Drax Biomass Immingham Limited

Planning Inspectorate Reference:TR030001

Drax Biomass Immingham Limited (DBIL) has been registered as an interested party with respect to the DCO application submitted by Able Humber Ports Limited (Able) for the development of the Marine Energy Park (MEP). DBIL has consent under Section 36 of the Electricity Act 1989 and an Environmental Permit for the construction and operation of a 299MW biomass fuelled power station (Heron Renewable Energy Plant to Heron REP) on land adjacent to the Port of Immingham and to the South of the proposed MEP. Having reviewed the documentation submitted by Able, it is evident that, without binding requirements/conditions being imposed, the proposed MEP has the potential to impact adversely on the proposed Heron REP.

Project:	ABLE Marine Energy Park
Client:	ABLE UK Ltd
Title:	Preliminary Layout of Foul Water Drainage System

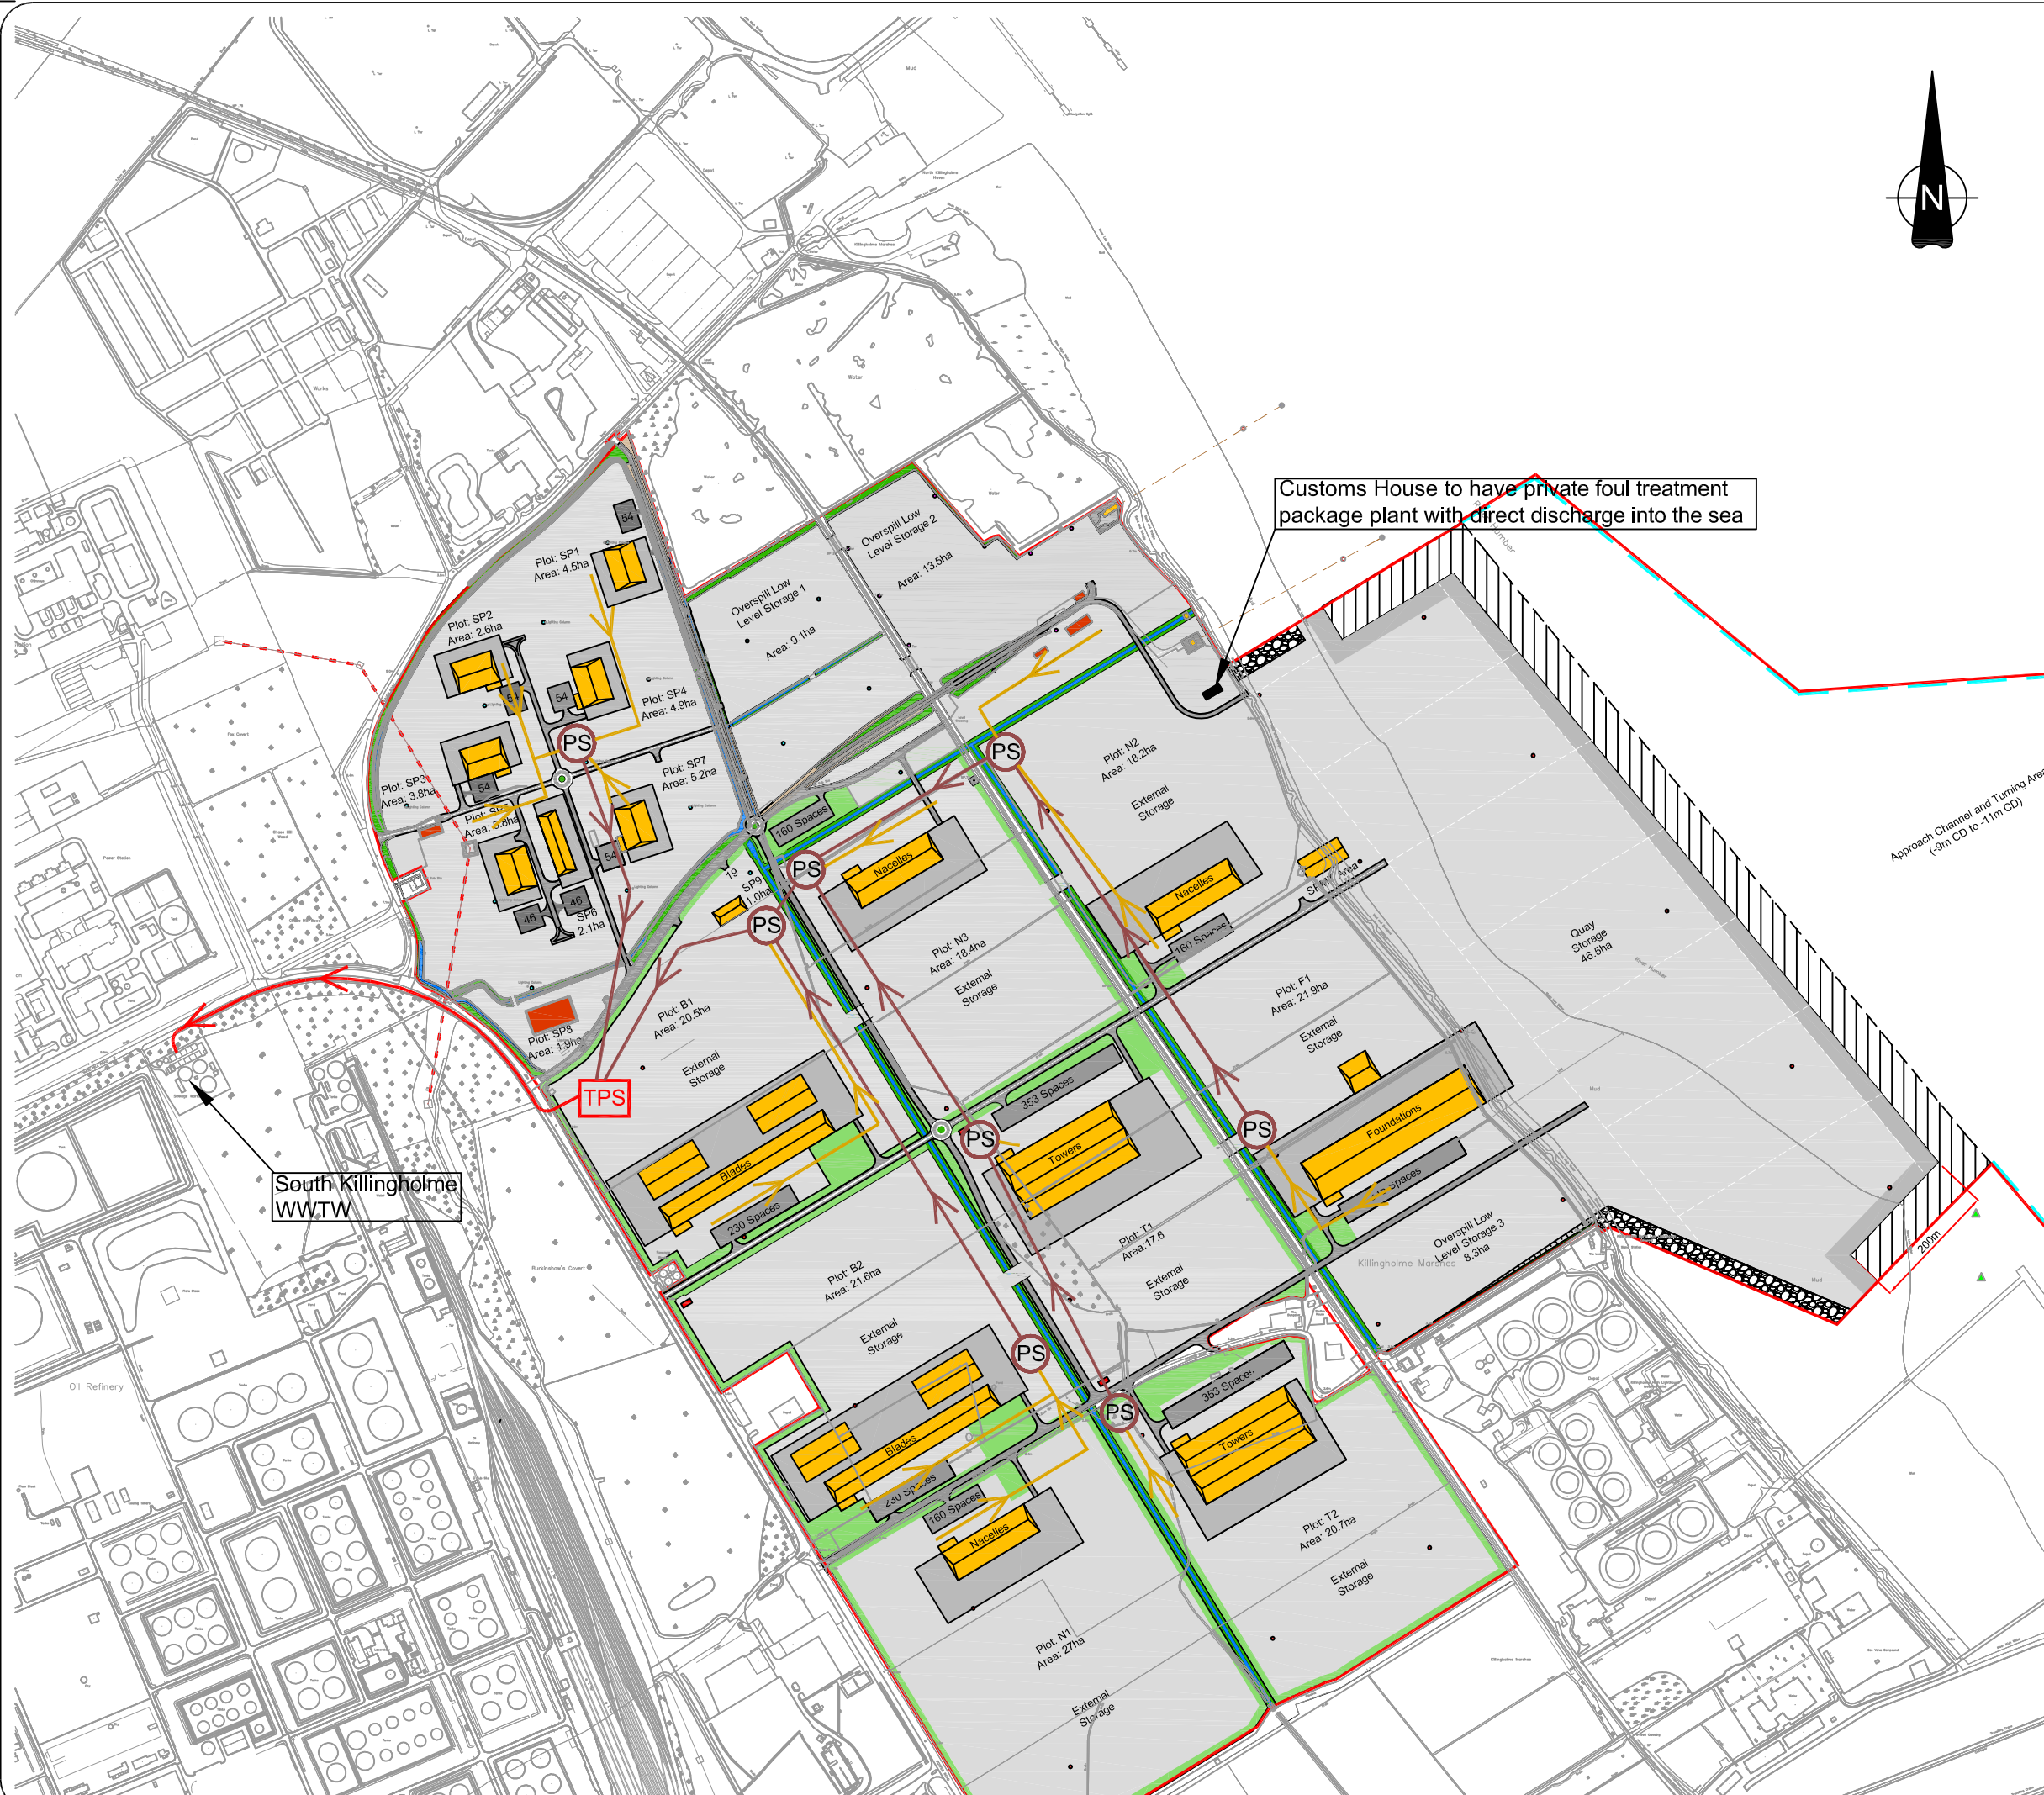
DBIL has had discussions with Anglian Water regarding the supply of potable water to the Heron REP. Anglian Water indicated that they would investigate the capability of connecting the Heron REP site to a potable water supply. When referring to the Site Location Plan, it appears that infrastructure associated with Anglian Water's assets have been included within the area covered by the DCO application. It would be beneficial to understand whether Able believe that there will be an impact on Anglian Water's assets. In addition, DBIL had also discussed the possibility of connecting into the existing sewerage system owned and operated by Anglian Water. Again, it would be beneficial to understand whether there is any potential impact on the ability of Anglian Water to provide services to treat domestic wastewaters.
